Subject: RE: Planning Consultation on: Y/72/20/RES

Engineers Comments Regarding Surface Water Drainage

Application No: Y/72/20/RES

Site Address: Land at Stakers Farm North End Road Yapton

Drawing Title
**DRAINAGE CONSTRUCTION
DETAILS (SHEET 3 OF 3)**

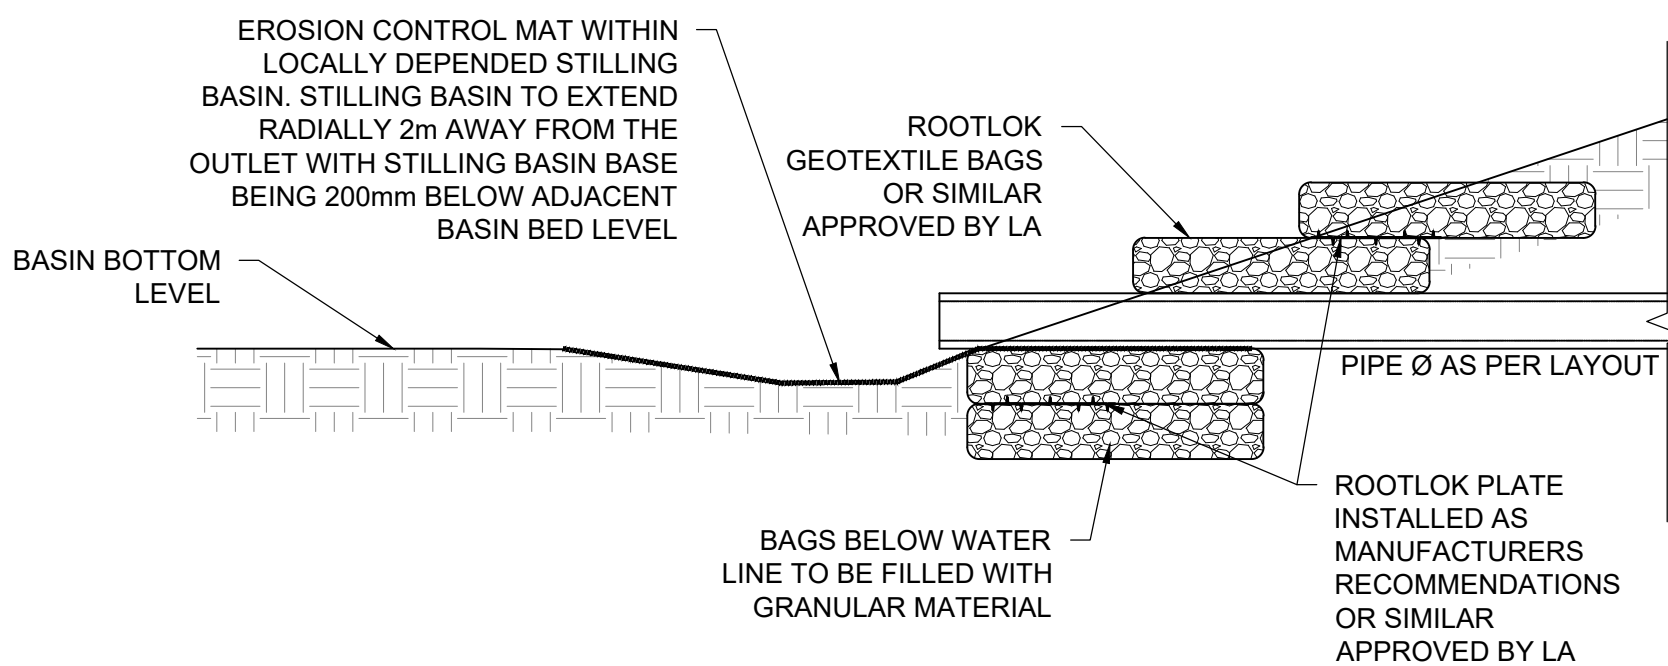
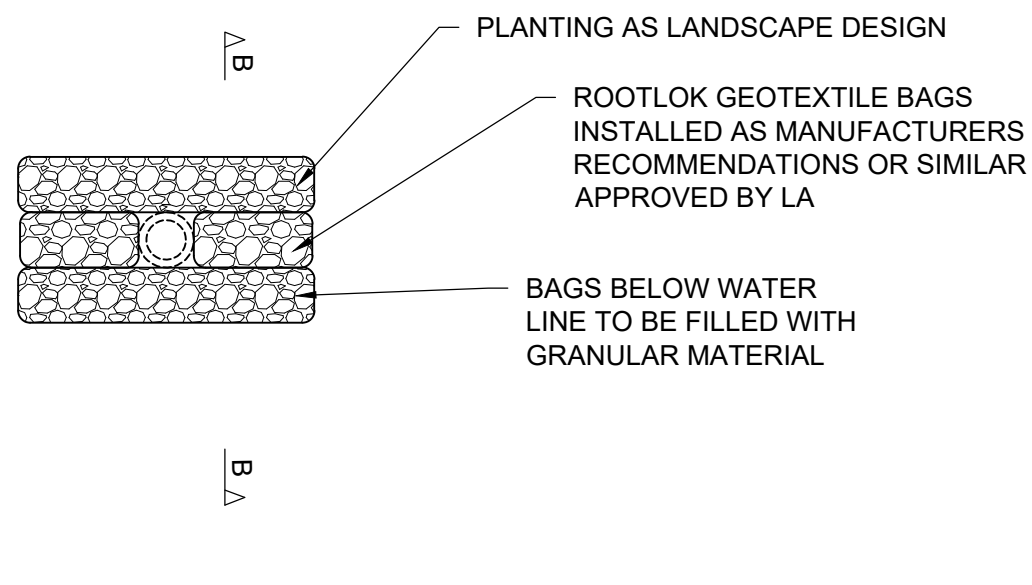
To confirm, we maintain our holding objection at this time, as detailed in our previous responses. It has not been evidenced that there is adequate space for surface water drainage.
